19 January 2021

re: **MP07_0179-Mod- 6 - Cabarita Mixed Use Development - Lots 184 – 187 & 191-194 DP 259164 and Lots 20-23 DP 31208, Tweed Coast Road and Hastings Road, Cabarita Beach/Bogangar (Now known as Lot 1, DP 1185345, 39 Tweed Coast Road, Bogangar)**

I refer to correspondence from the Dept of Planning, Industry and Environment dated 18th December 2020 and advise as follows;

TWEED COAST ROAD ELEVATION
AMENDED APPROVAL COMPARISON

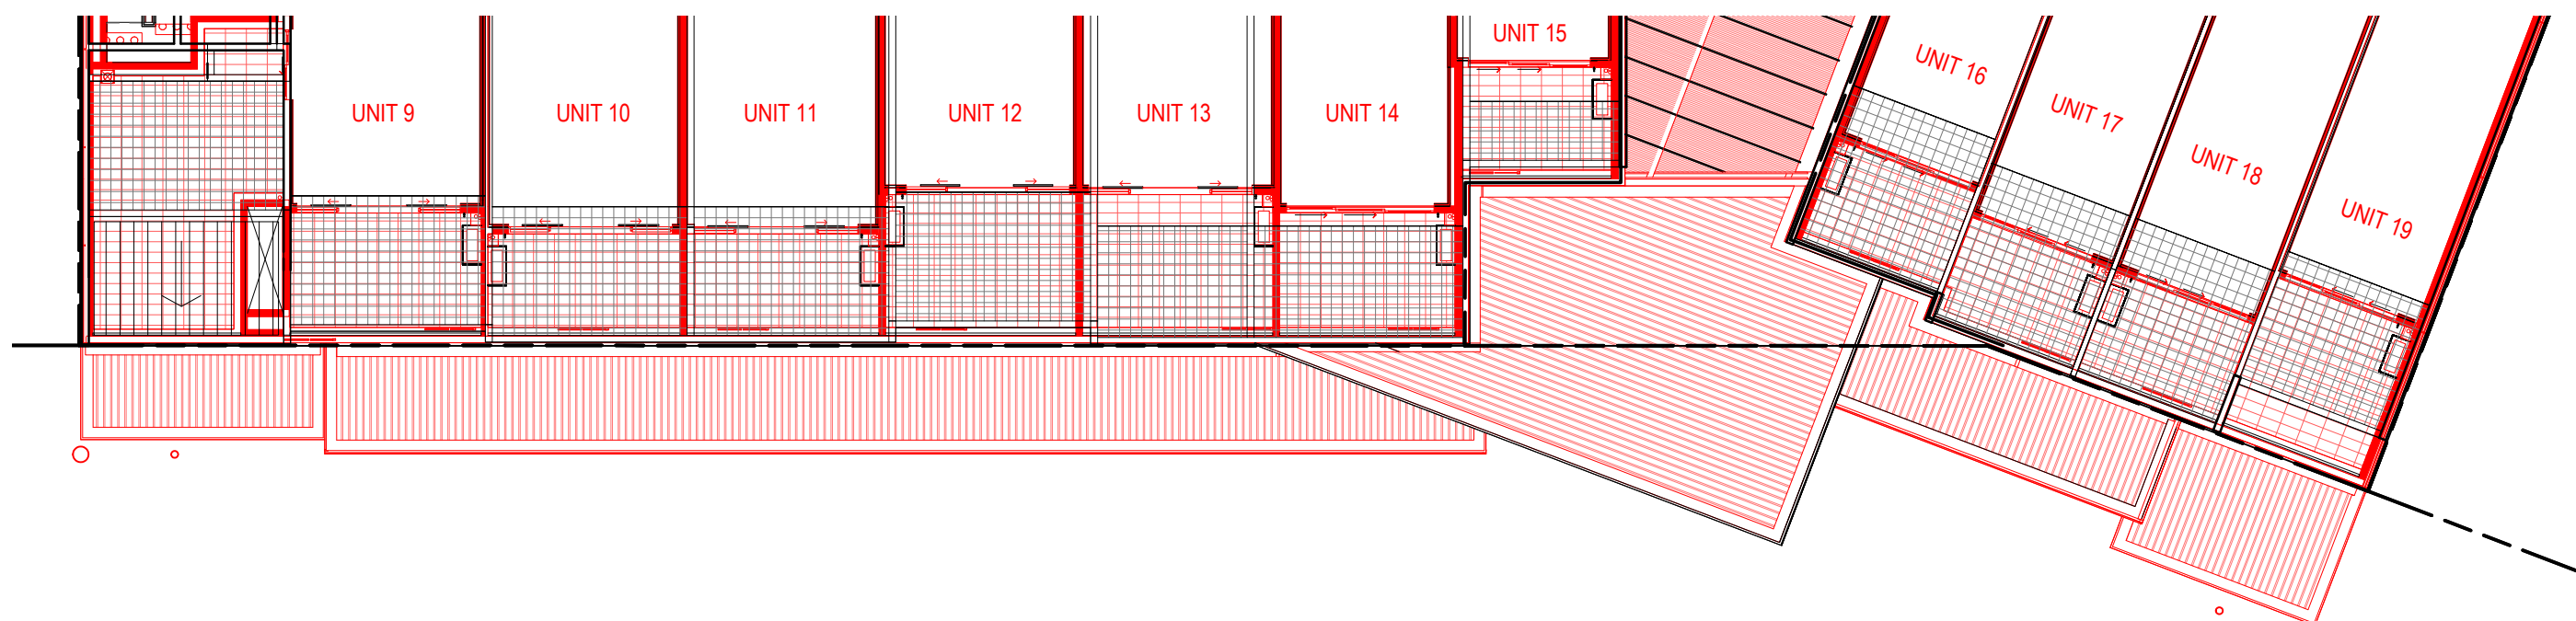
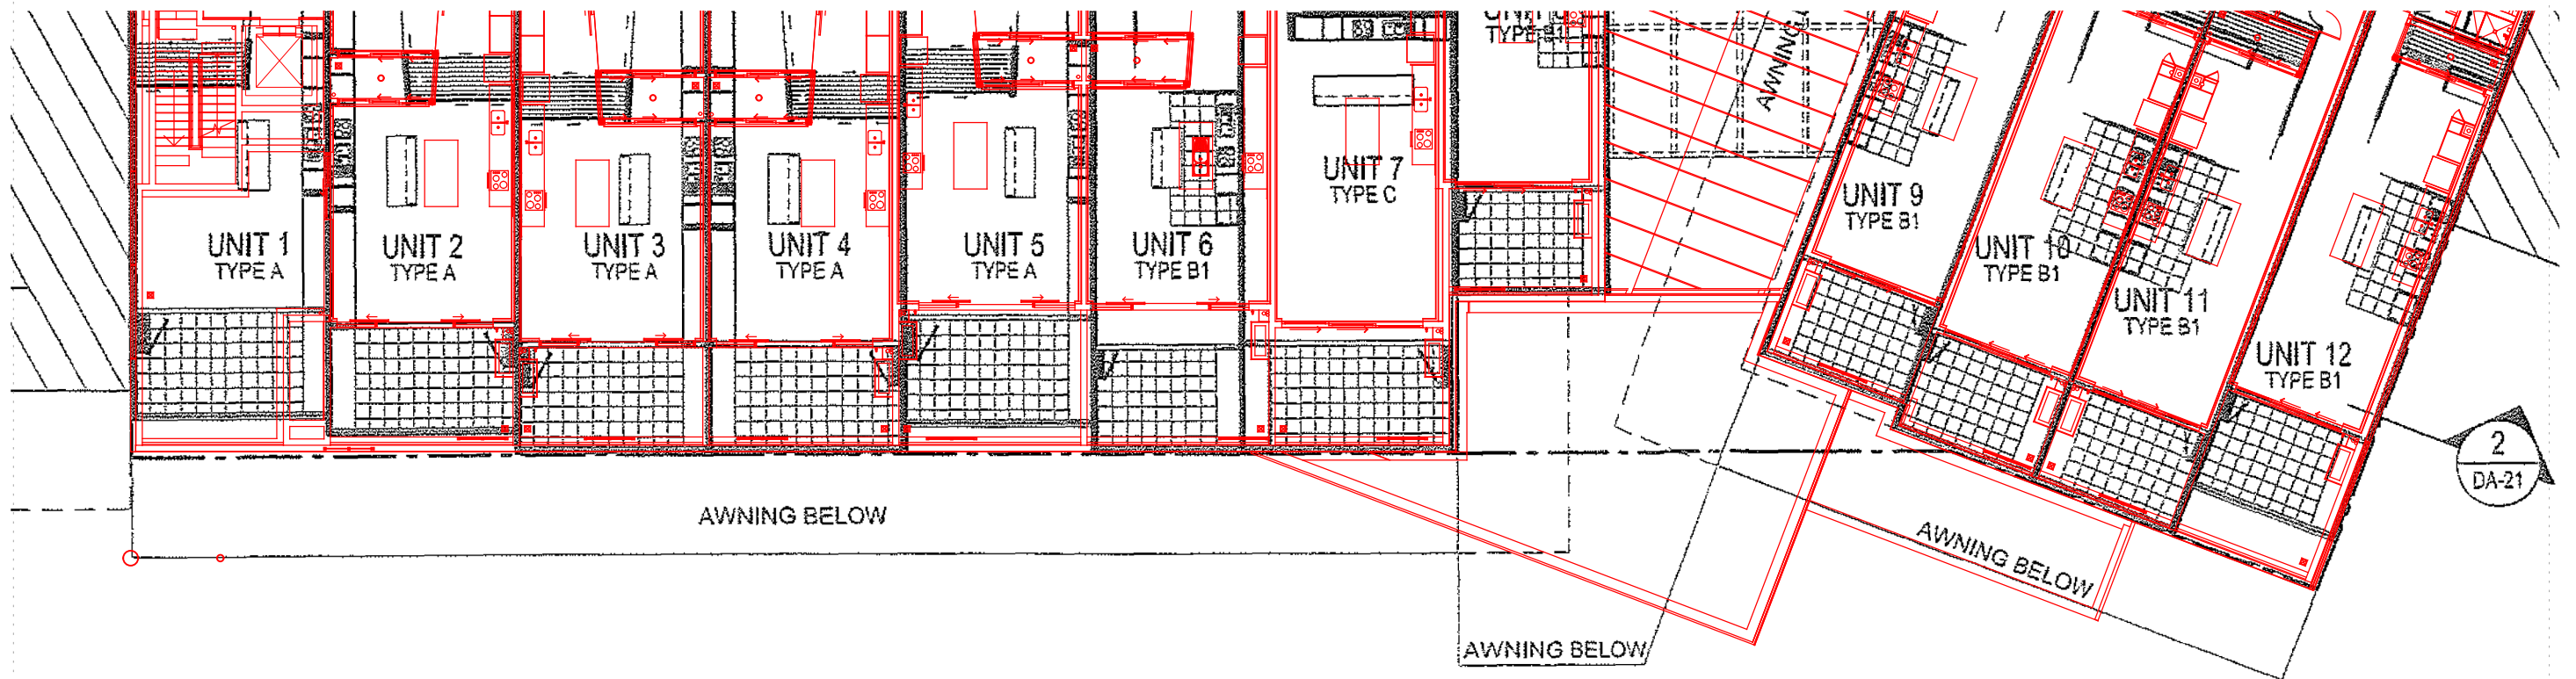
- **Tweed Coast Elevation**

The modulation of the balustrade of the Tweed Coast Road balconies has been modified due to the existence of a parapet wall along the eastern edge of the building (presumably a balustrade required for safety reasons due to the staging of the development) – this adjustment will not be seen by the public as the balconies are concealed behind the existing parapet wall. Modulation of the eastern wall of the building has been maintained despite the balustrade position having been adjusted.

The balconies of the northern units are the same size as on the original approval, but smaller when compared to the modified approval - refer to the attached overlay of the current floor plan over the original approved floor plan.

TWEED COAST ROAD ELEVATION ORIGINAL APPROVAL COMPARISON

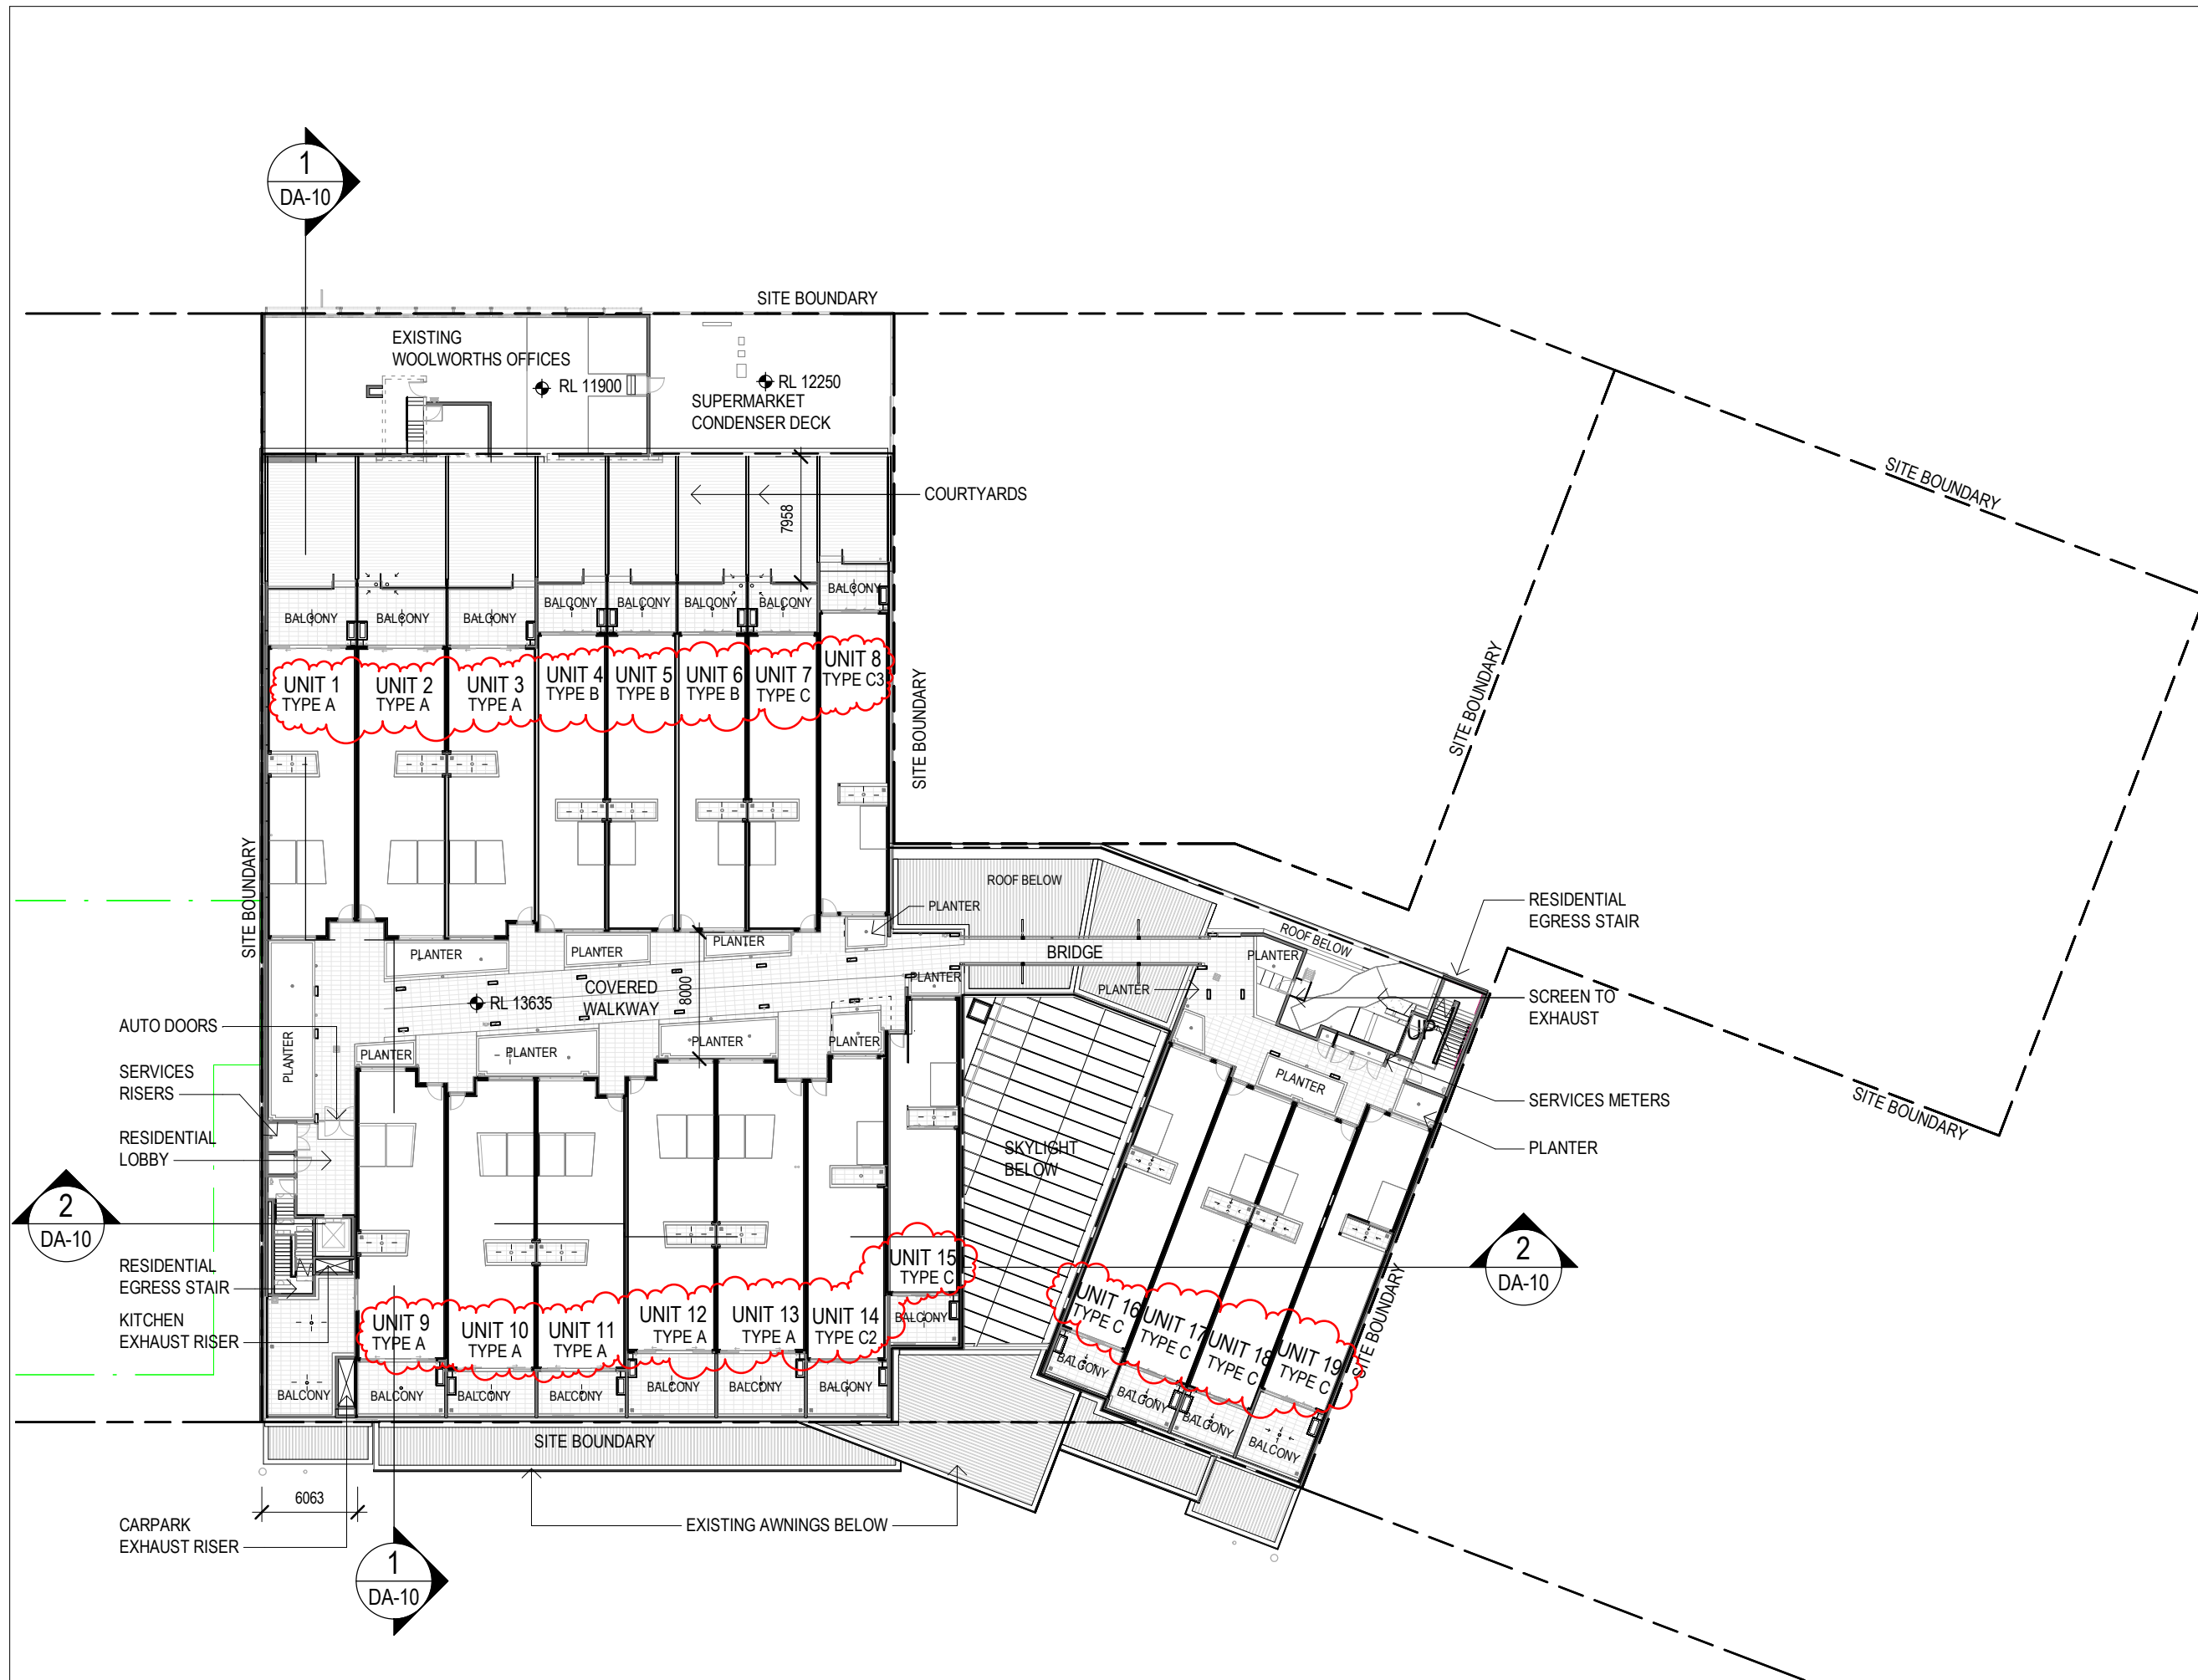
The south east corner balcony has been extended to the existing parapet wall as it is not visible from the street. Articulation of this end of the building is enhanced by the expression of the carpark exhaust riser in this location.

project no P1710	scale 1 : 400	@A3
dwg no DA-05	rev no C

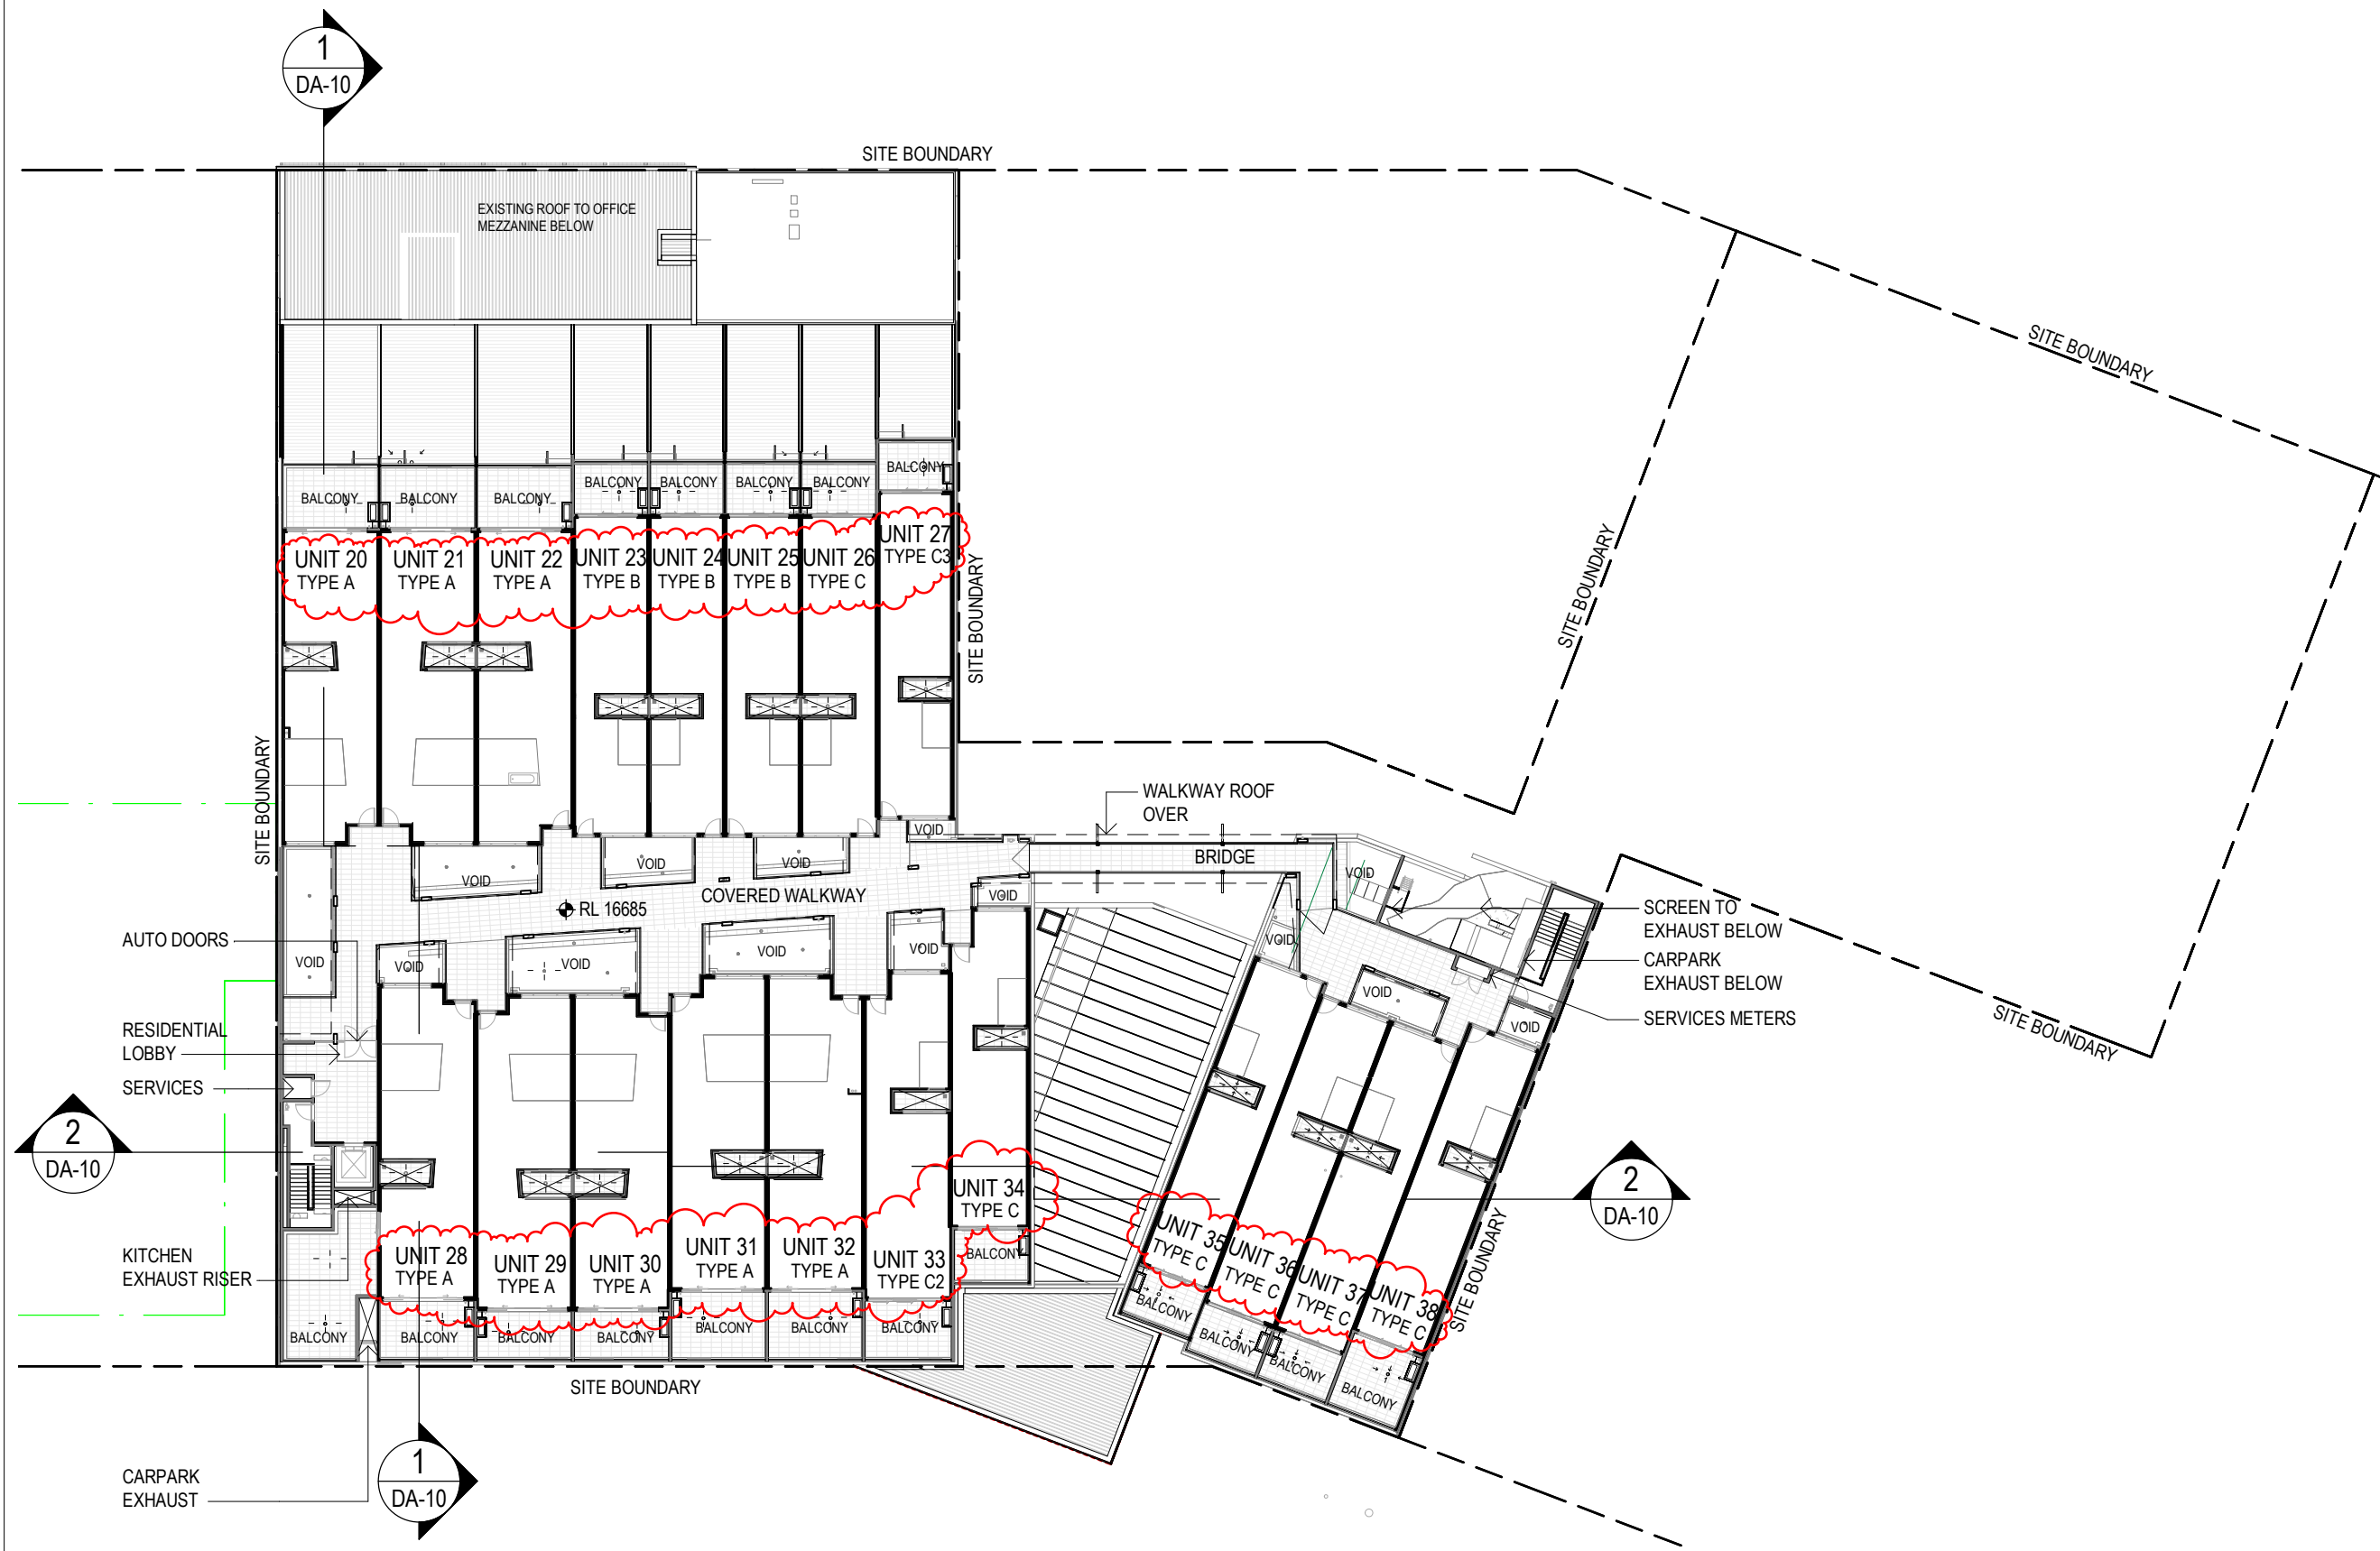
- **Unit Naming**

Floor plans for levels 1 and 2 have been updated by changing “Lot” to “Unit”. We have avoided changing the numbers for each of the units because it is not possible to achieve complete consistency given that two units have been deleted (was 40 units, now 38 units). Refer drawings DA.05 and DA.06.
